Application for Planning Permission

Demolition of existing single storey side extension and construction of an attached two storey self contained dwelling.

2 Worcester rd, planning re-consideration

28/07/2022

Description: PROPOSED PLANS & ELEVATIONS.

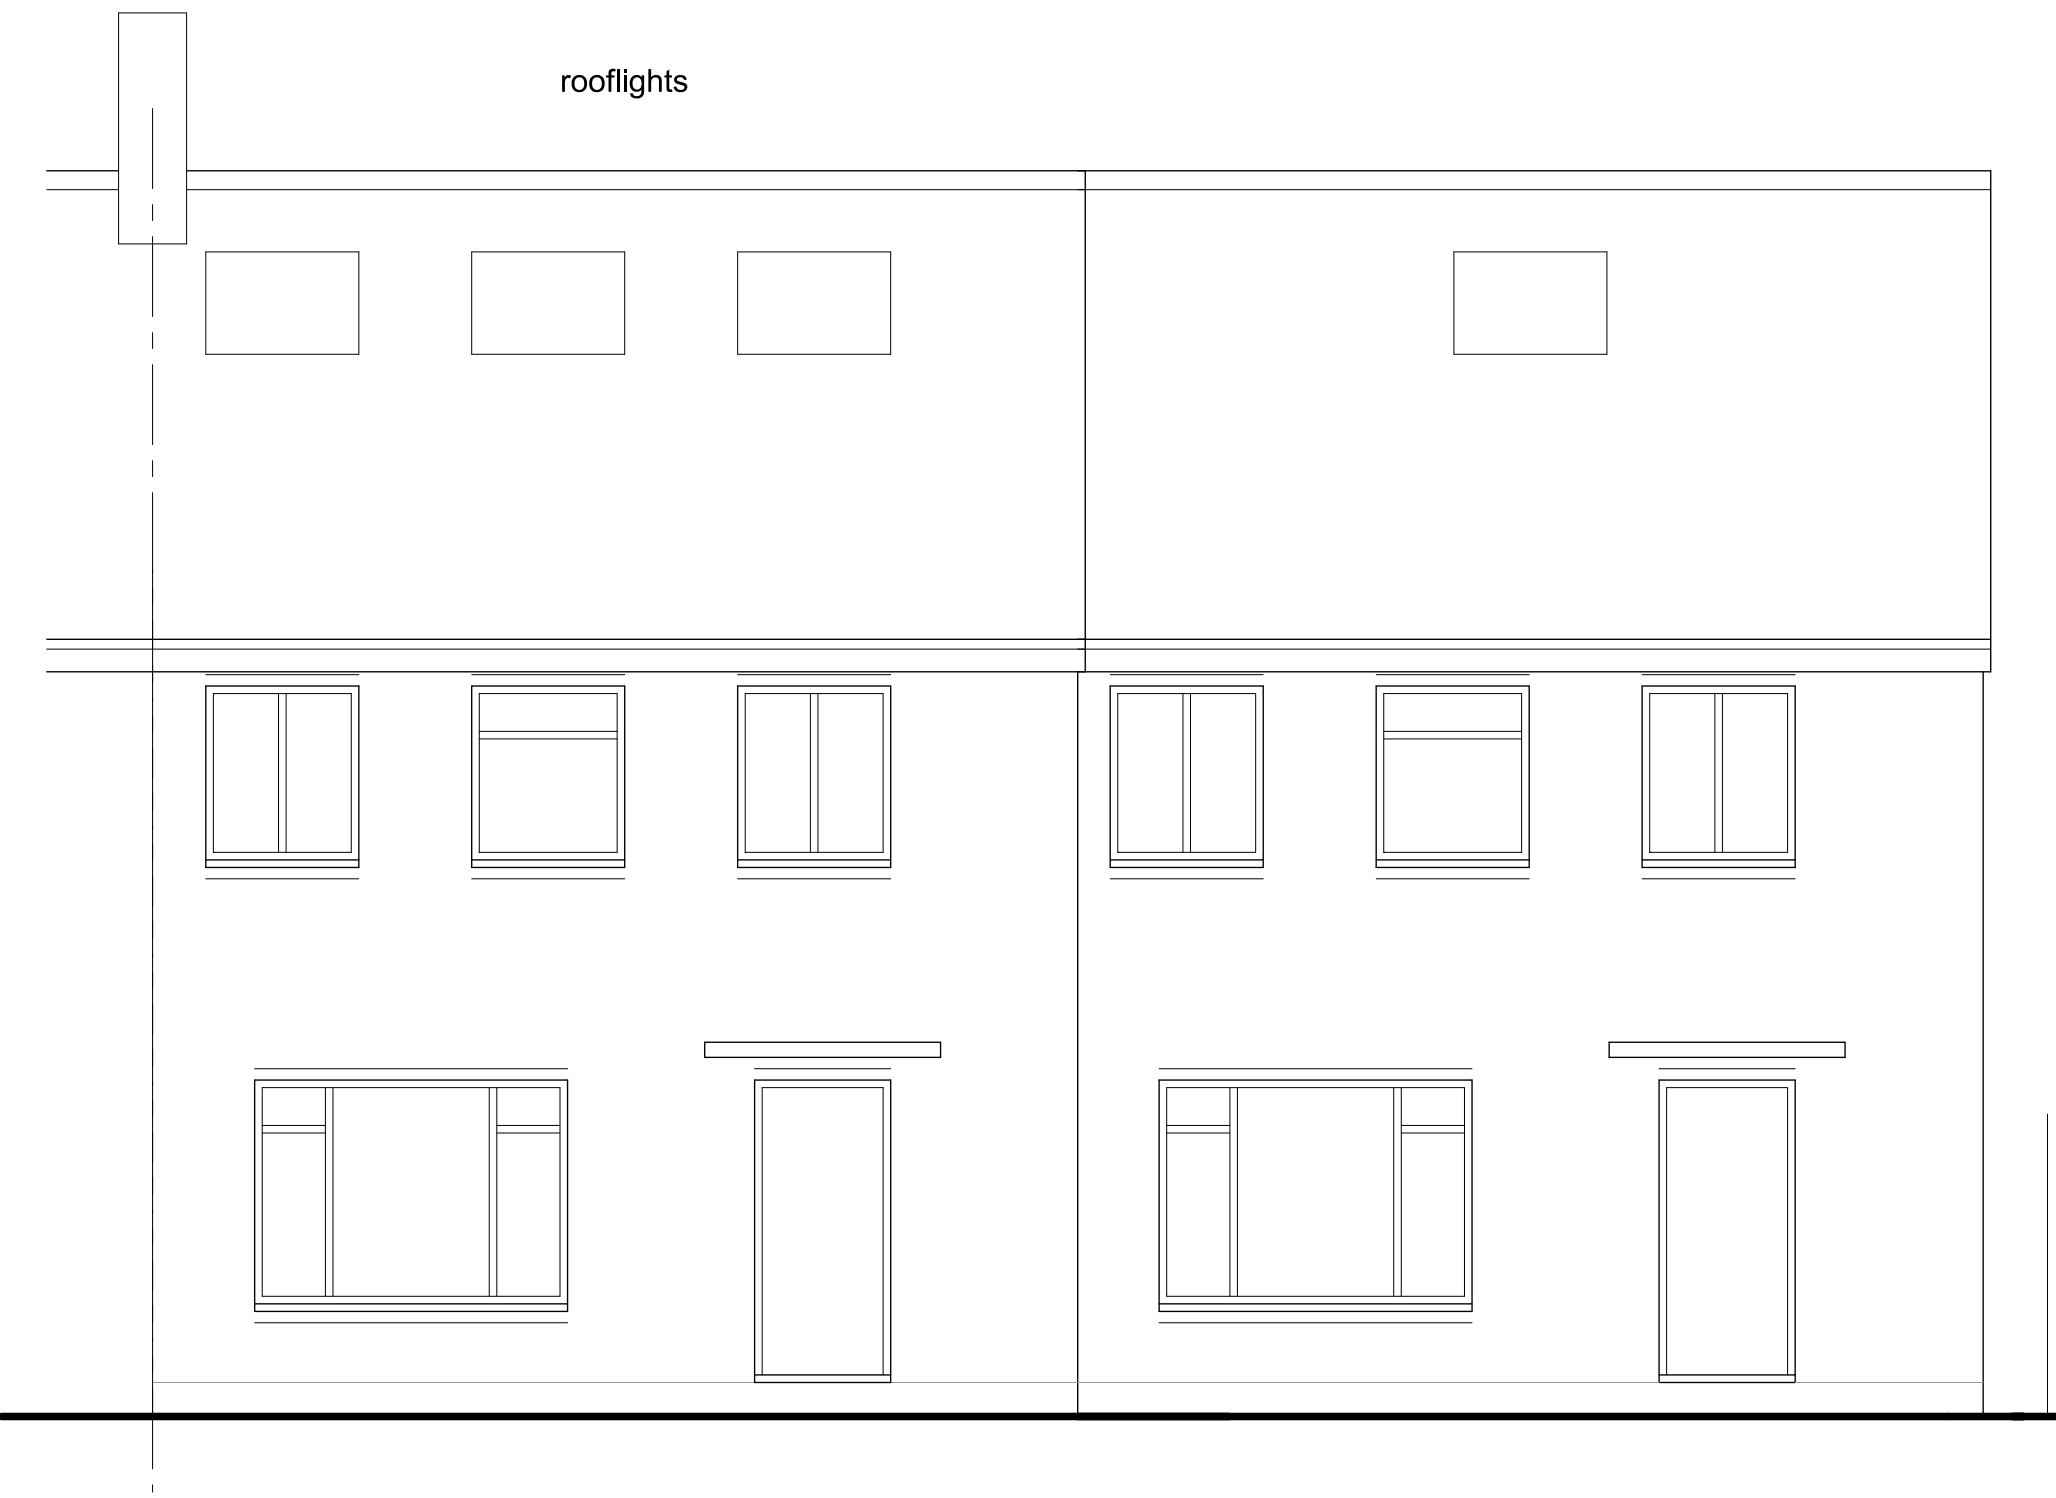
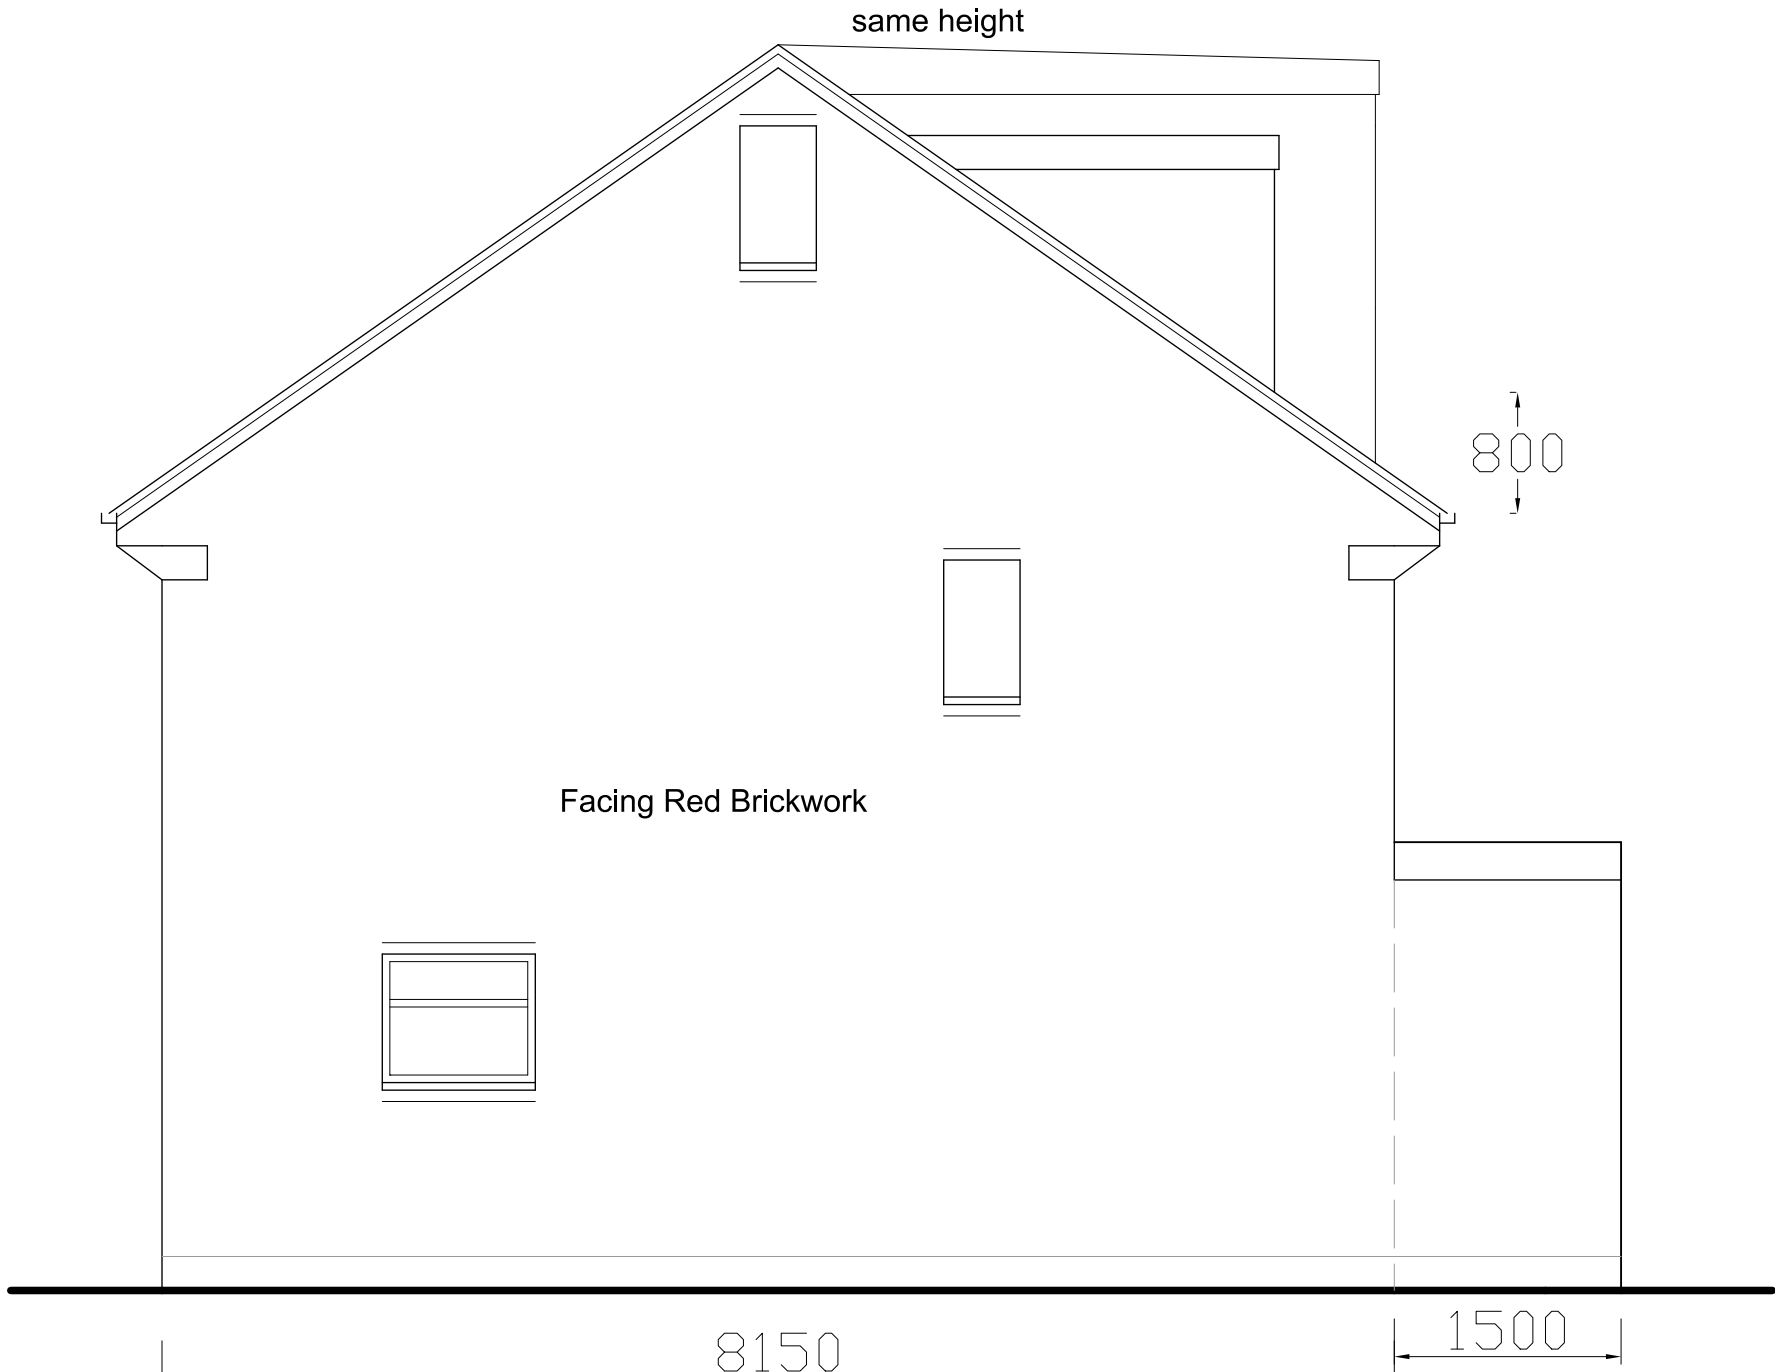
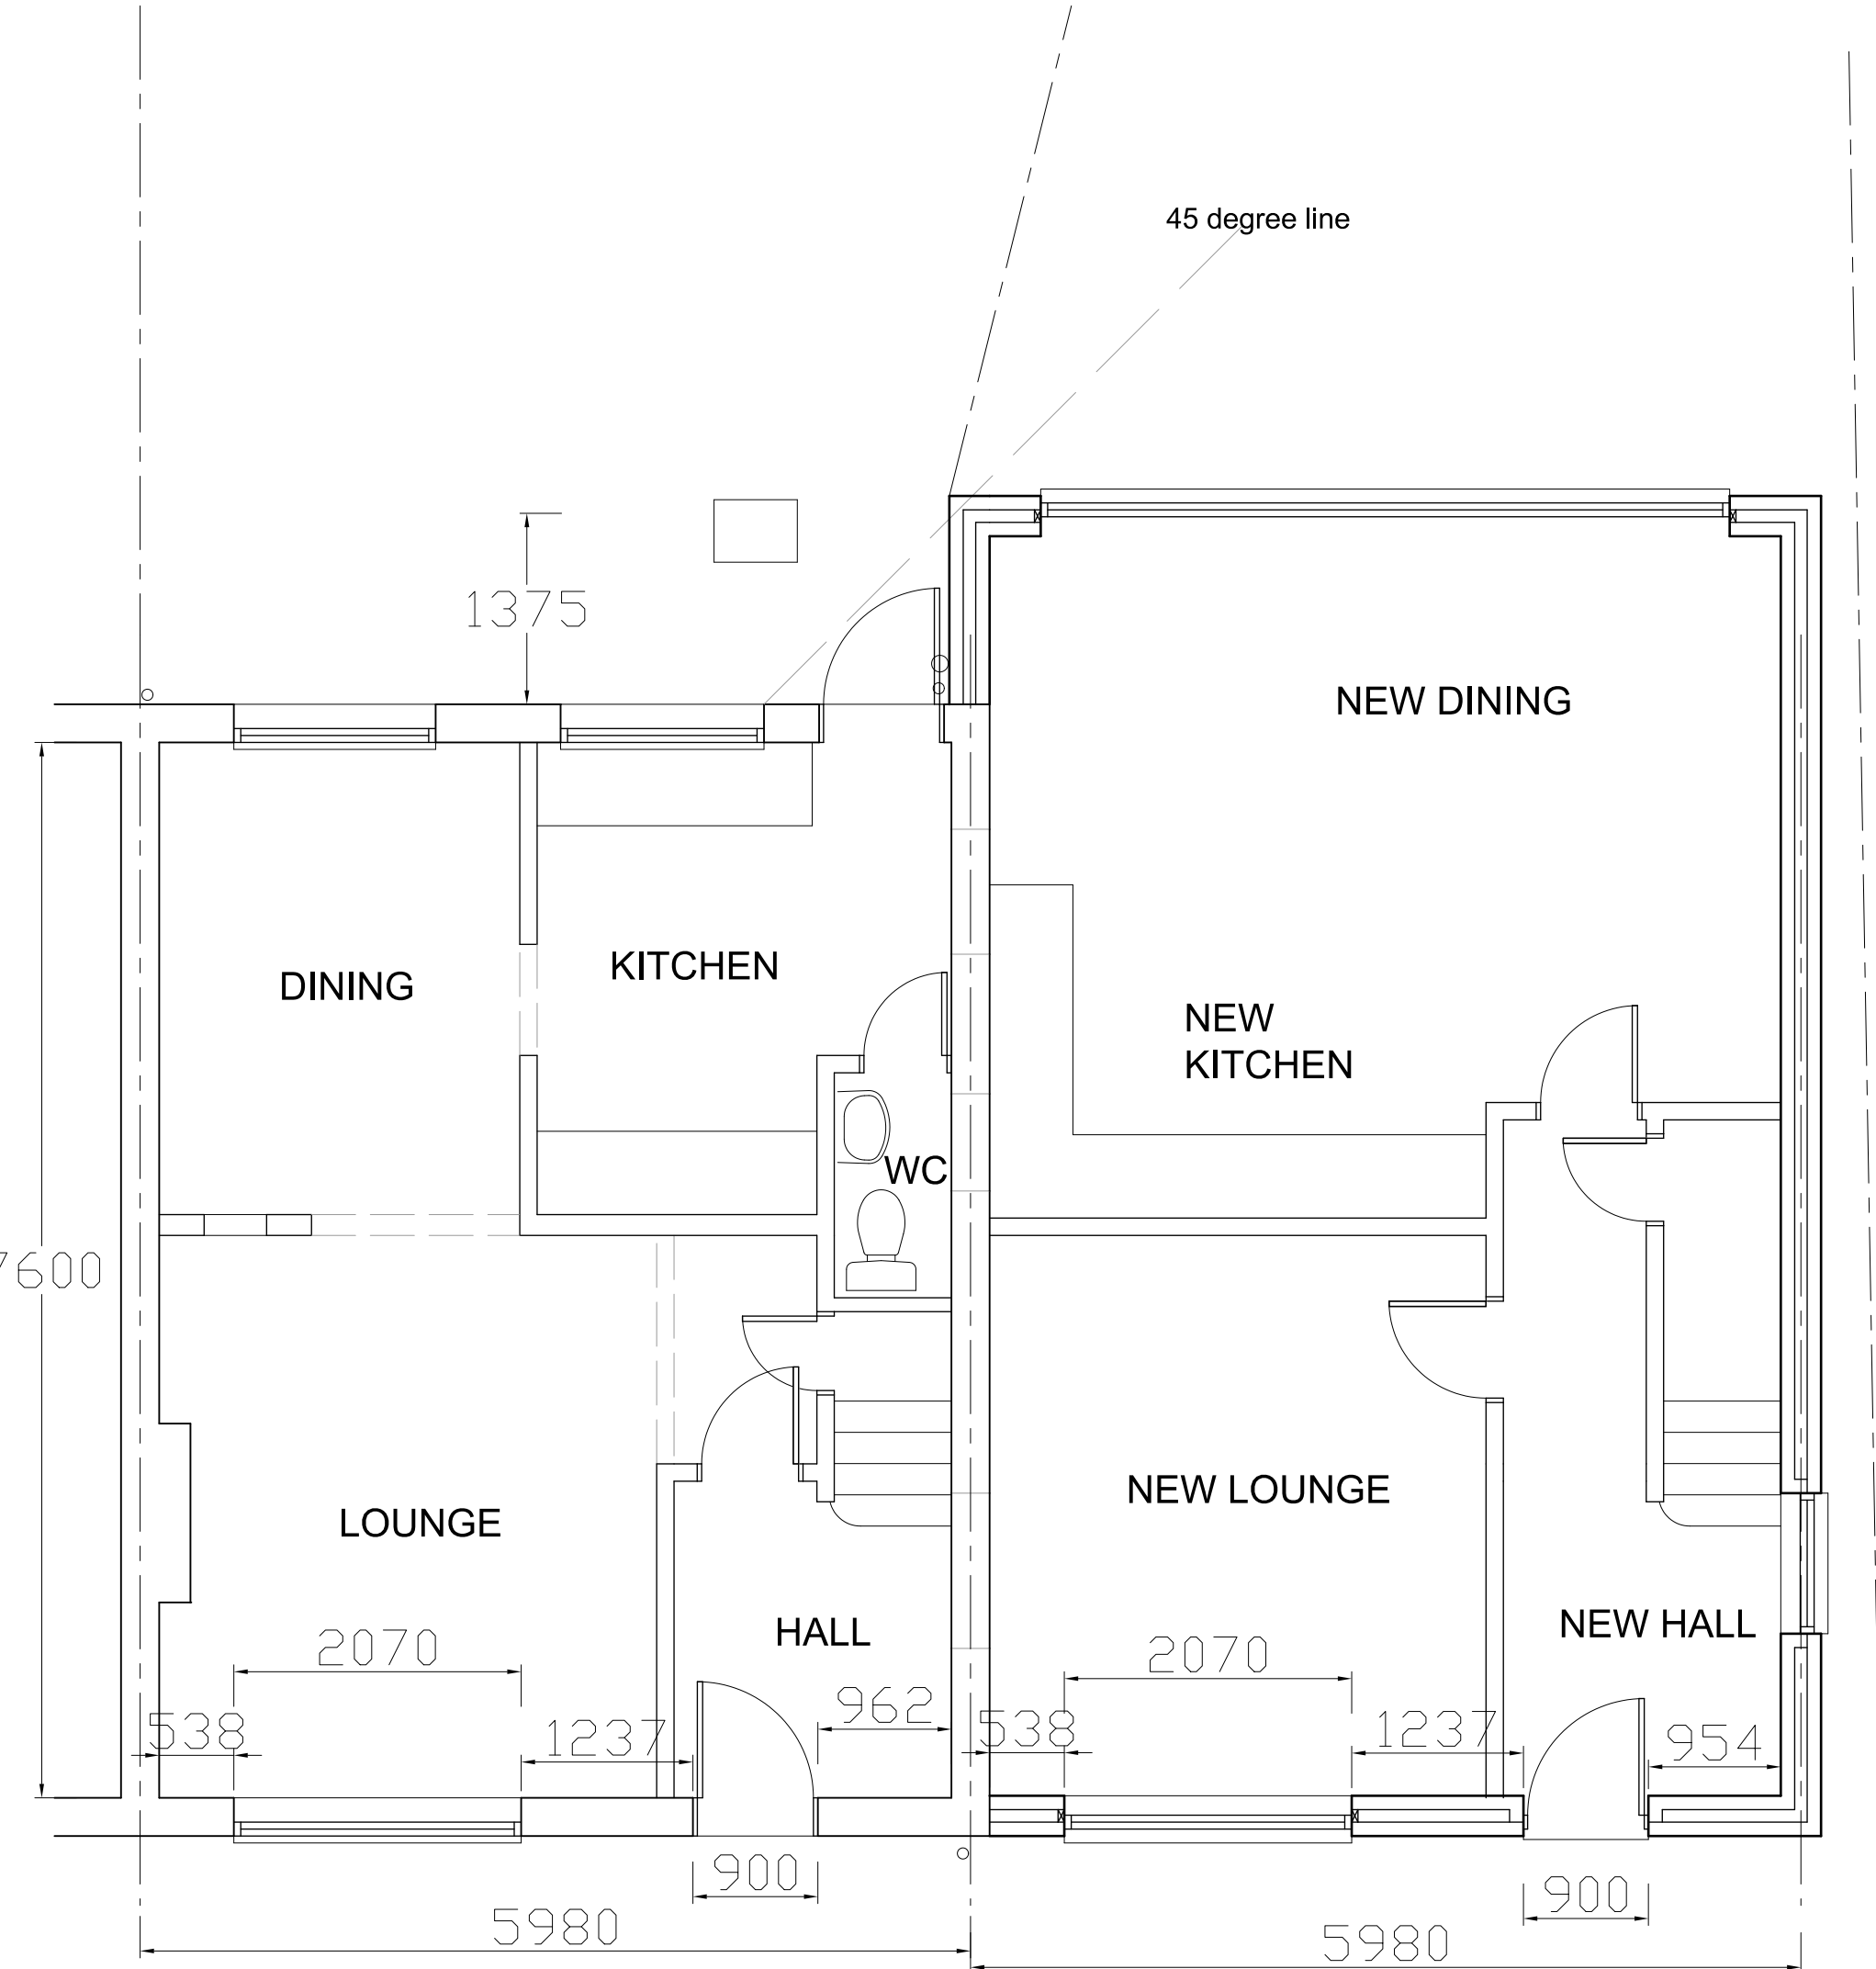
We would accept a reduced set-back but this means you will need to provide refuse storage in the front garden since there'd be limited access to the rear down the side.

We would accept 1 parking space for the new two-bed dwelling. This would be in accordance with the local plan where only one would be required for a one or two-bed unit. The existing 3-bed would need to retain the 2 spaces.

I have reviewed the previous refusals and two appeal decisions. My recommendation for an application that may be looked upon more favourably is to replicate the proportions, scale and appearance of the existing dwellings. Specifically this would be:

- The new dwelling needs to be attached to form a terrace. The street is characterised by consistent spacing between the pairs of semi-detached homes. A detached dwelling cannot duplicate this given the plot width.

- The plot width of the new dwelling should be the same (or as close as practicable so that any variation is visually negligible) as that of No. 2 and the other dwellings on the road. This means that the new home width would be the same as the other dwellings and the appearance can be duplicated with the same three windows, same ground floor fenestration etcetera. In other words the new home needs to look exactly the same. However it is important that the side elevation is not splayed, this would be too conspicuous in the street scene. It needs to be straight like the other dwellings.

- As with the advice above, the front building line and the principal rear building line needs to be the same as No. 2 so that this reads as a terrace of three dwellings. It may be possible to add a small single story rear extension and small rear roof dormer if additional floor area is needed to meet minimum GIA requirements.

- The materials, fenestration design and overall design needs to match the other adjoining and adjacent dwellings.

- You use the existing dropped kerbs and don't seek to widen these
- There should be enough clearance within the forecourts of both dwellings for pedestrians to access the entrance to each house
- Ensure that the garden space for both homes complies with at least 60sqm (for a 2-3 bedroom home) or 100sqm (4+ bedrooms) and are genuinely usable and of good quality. These should take the form/layout of a standard lengthy rear garden to mimic the typical garden layout in the area.
